Application number: 2020/94203.

The application is for demolition of dwelling and associated outbuildings etc.

The address of the site or building is: Clough House, 236 Leeds Road, Birstall, Batley, WF17 0HW.

The following comments represent an objection to the above mentioned application:

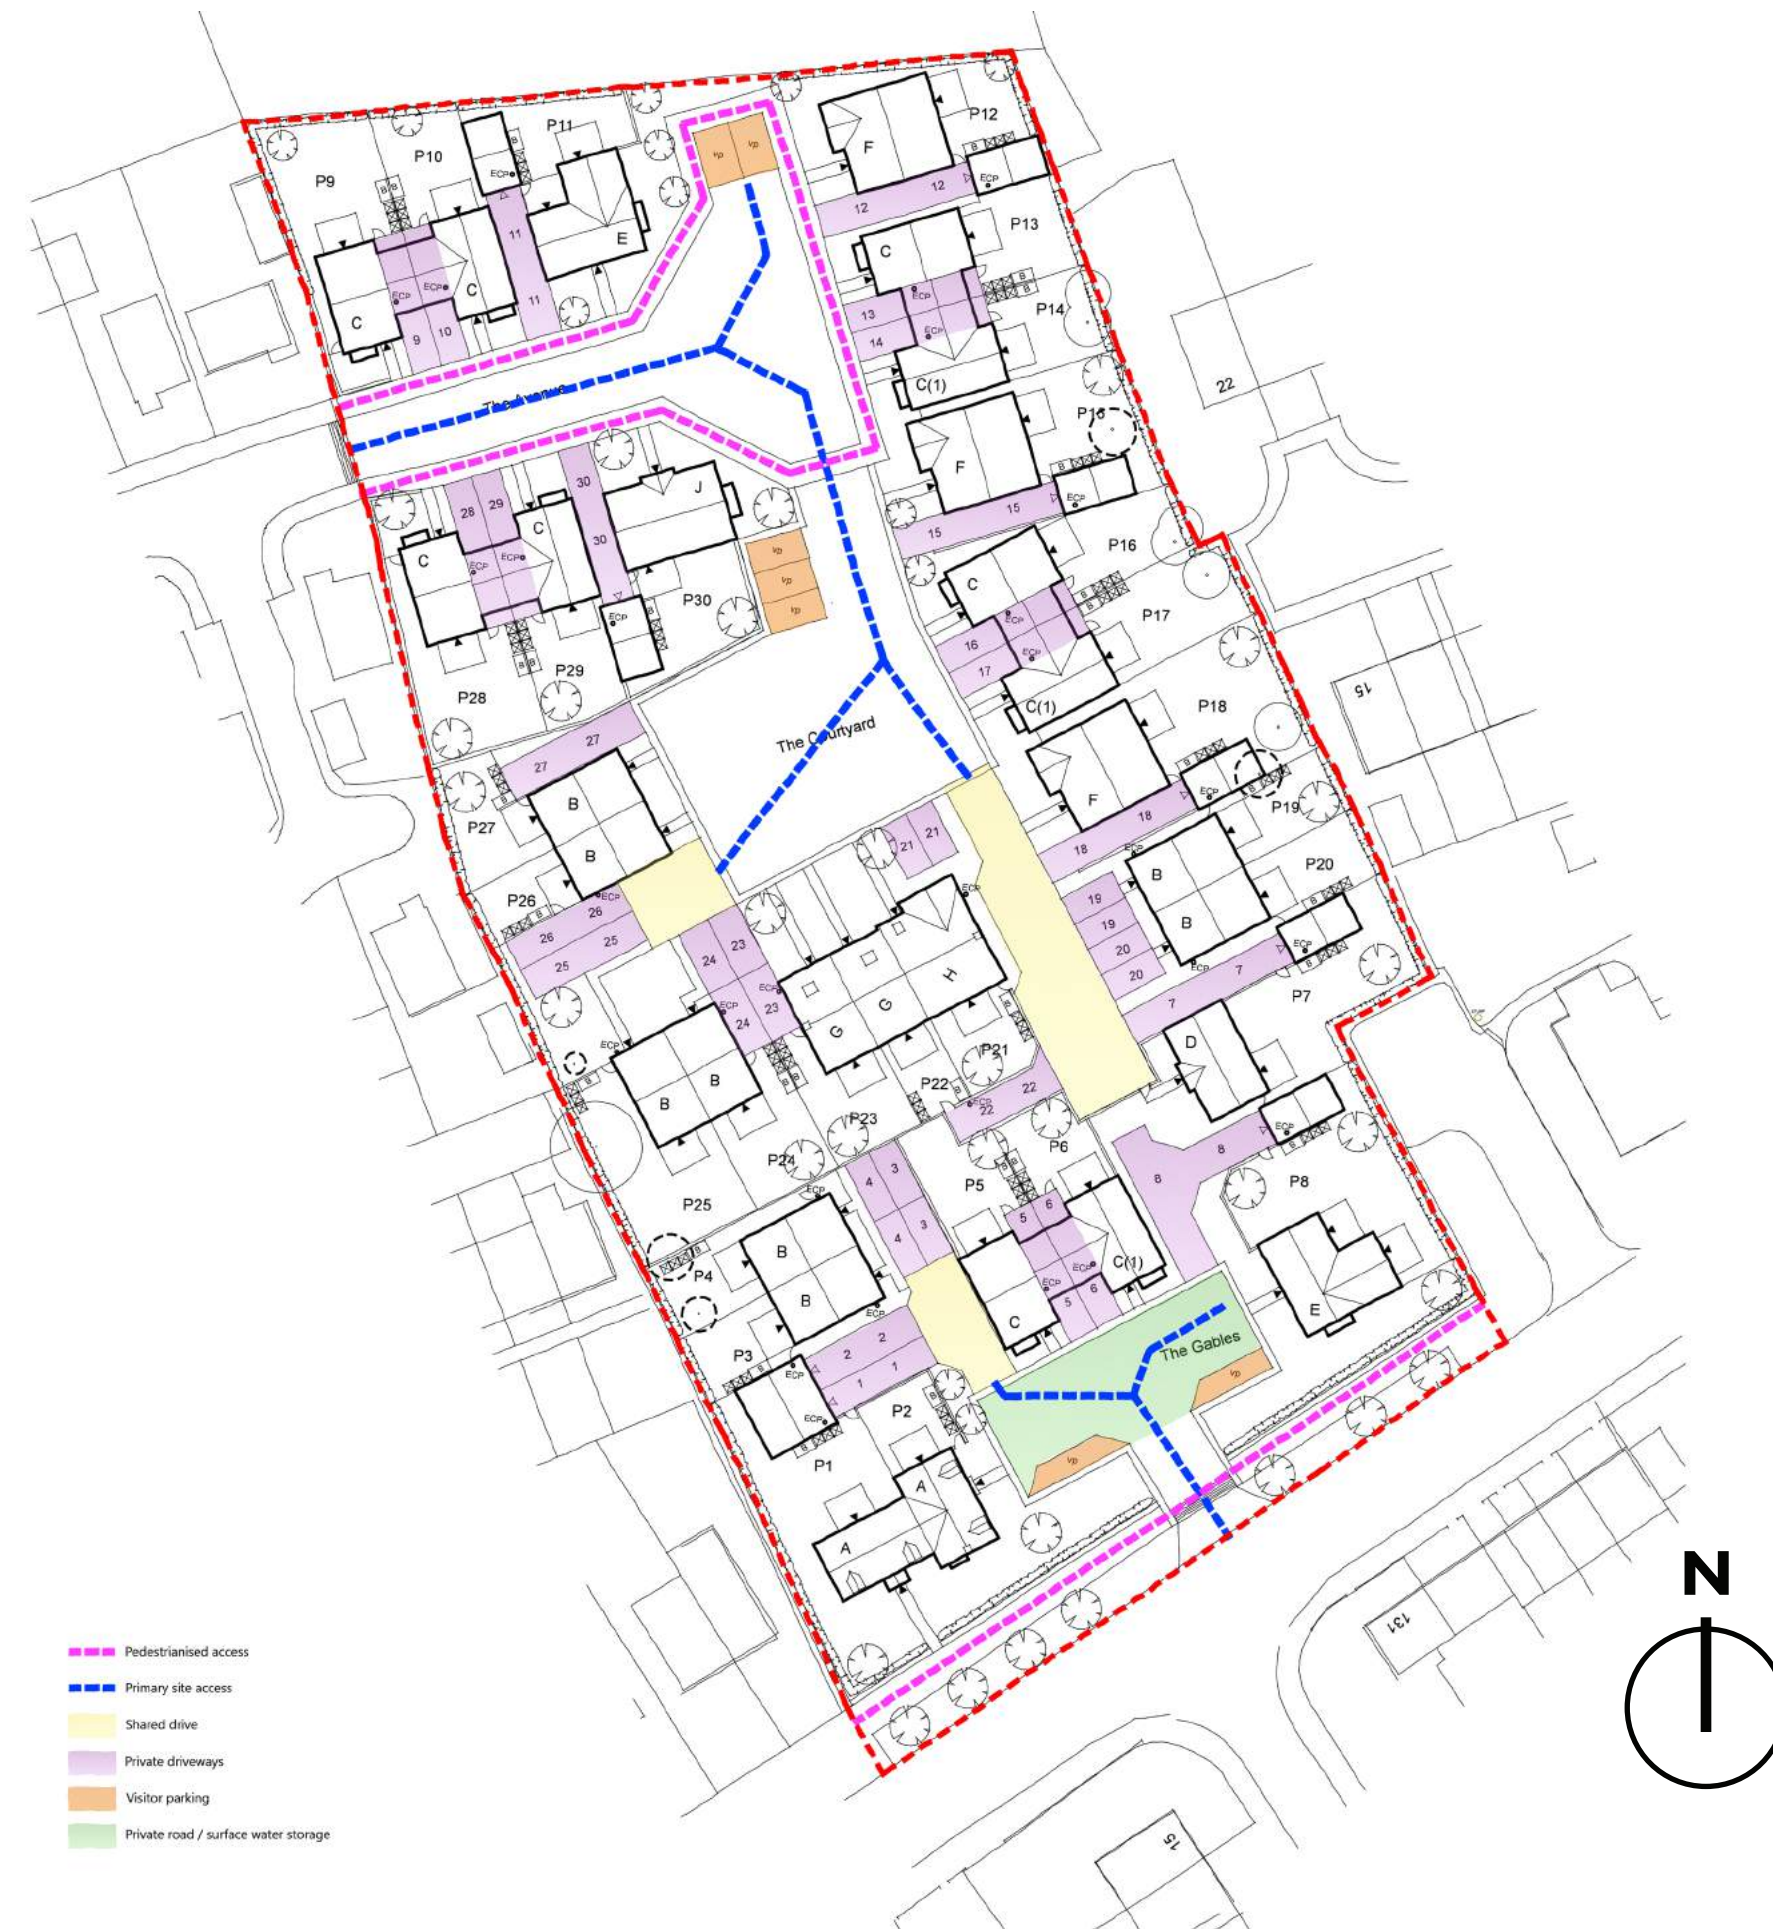
Having perused the plans and associated documents, I was surprised to see that the development would be split into two cul-de-sacs, with 23 dwellings in the 'northern' cul-de-sac, utilising the proposed access from Moat Hill Farm Drive, and the other 7 dwellings in the 'southern' cul-de-sac (which seems to be somewhat insular) with their own access via the A643, Leeds Road, but no vehicular access to either the 'northern' cul-de-sac, or elsewhere.

Another objection to this application is the fact that Moat Hill Farm Drive has been selected as an entry/exit route for the proposed new development. I consider that this is a most unsatisfactory choice – for reasons which follow. I feel that this has been planned with very little (if any) consideration to adjoining residential areas (i.e. Moat Hill Farm Drive, and the residents thereof)

The Paragon Highways report - submitted in support of this application, under ‘Supporting Information – Transport Assessment’ indicates that this is an estate road with a width of 5.4 metres. This is hardly a suitable thoroughfare for the possibility of having to cope with an increasing volume of traffic, pedestrians and cyclists etc. A further 10 properties are nearing completion, at the top of Moat Hill Farm Drive, and if a further 23 properties were forthcoming, this would virtually double the amount. Even now, the residents of Moat Hill Farm Drive are experiencing problems with the narrow (estate type) roads. There is an ongoing problem with these narrow roads. If vehicles have a need to park here, and park legally (i.e. on the road, and not half on the road, and half on the pavement) the roadway is instantly reduced to single passage. Apart from the regular Waste collection vehicles, Post Office vans, emergency vehicles, regular delivery vehicles (especially during Covid) – we have for the past year had a multitude of large and small vehicles working on the building site for the 10 new houses. These, thankfully, are virtually completed. The thought of another lengthy period with regular noisy and heavy construction traffic utilising these narrow streets is unbearable. In the upper part of Moat Hill Farm Drive there are elderly residents (in their 70’s and 80’s) who can move around safely. There are also families with young children, who can cycle and play in relative safety. This was the prime reason for both these groups of people moving to the area. This would change dramatically if the cul-de-sac was ‘opened up’. Another factor which should be taken into consideration is the fact that most of Moat Hill Farm Drive consists of a steep incline, which during the winter months regularly becomes virtually impassable when snow and ice are present – resulting in treacherous conditions for vehicles, cyclists and pedestrians. The past few days, with such conditions, have been a reminder of this, with conditions requiring residents to apply their own sand and gravel to the roads to allow cycles, pedestrians and vehicles on

essential journeys to proceed, hopefully without any mishaps. Also on the junction, when exiting Moat Hill Farm Drive to Leeds Road, there is impaired visibility, due to the gradient of the hill on the main road and the regular presence of vehicles parked on this road.
